Narrabri Gas Project - Aboriginal Cultural Heritage Assessment

Expert Review

Peter Kuskie, South East Archaeology

May 2017

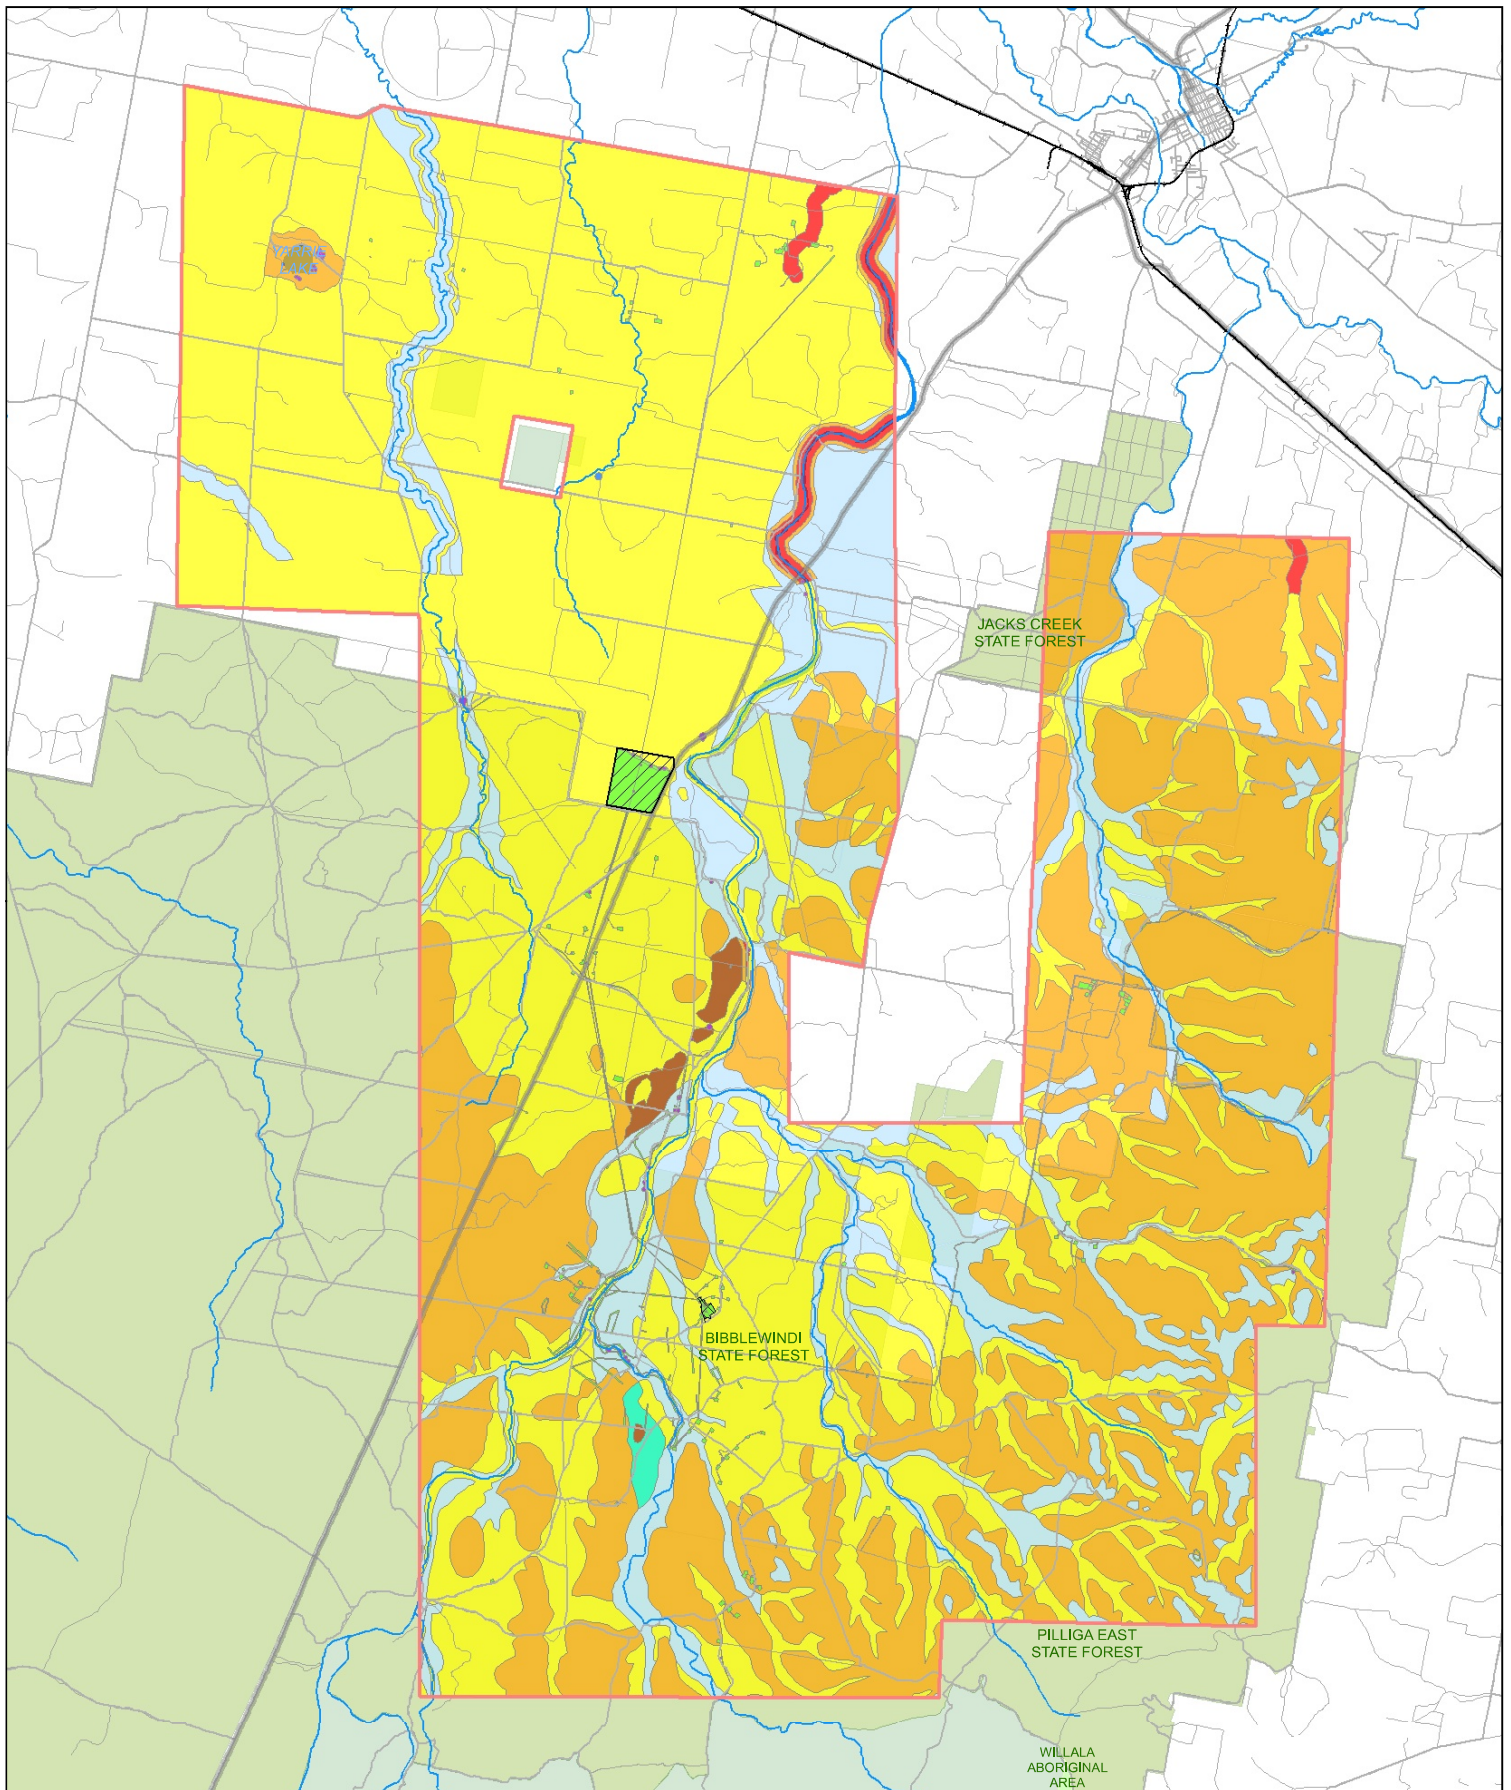
The classification of areas into 'zones of sensitivity' (a 'de facto' predictive model), particularly Zones 3a-3f, is in my opinion fundamentally flawed. There is no causal or logical link between the previously outlined environmental and cultural data in the ACHAR, and the predictive mapping. There is no model of occupation, that for example elucidates the relationship of occupation (including different forms of occupation such as encampments by small parties during hunting/gathering, nuclear/extended family base camps or encampments by larger groups, or including different time durations of occupation such as very short term through to longer term, or including the effects of repeated occupation caused by return visits during the seasonal or annual round) with relevant environmental variables (such as proximity to and nature of water source, landform unit, gradient, vegetation and geology).

Proximity to water (and generally only streams, not billabongs, lakes or Gilgai) and broad landform systems are the only environmental variables relied upon by the authors for development of the 'zones of sensitivity', with minimal rationale for the manner in which they are used, and a very sparse and inadequate baseline dataset (only one known site for every 354 hectares) from which inferences are extrapolated.

The use of stream-order numbering opposite to conventional geographical numbering is problematic, as is the refusal to use high-quality LIDAR data available for the Project area, that would have enabled much finer resolution of landform units, water sources (including billabongs and lakes) and even the location of rock formations.

CQCHM themselves acknowledge this in Section 4.7.2 of the ACHAR with the statement that "the differential sensitivity attributes which constitute Zone 3 should not be viewed as being an accurate reflection of the probable or even possible cultural landscape of either the Data Audit or Project areas".

On the basis of this admission by CQCHM and the inadequacies outlined above, the predictive modelling and CHZS should be set aside.

Separate mapping 'zones' are strongly warranted for each of the Aboriginal site types with potential to occur in the Project area, and with consideration of the spatial distribution of environmental and cultural variables relevant to those site types (eg. the potential for rock shelter sites could be mapped with respect to the distribution of rock formations derived from underlying geological mapping and LIDAR data, and the potential for scarred trees could be mapped with respect to the distribution of mature native vegetation).
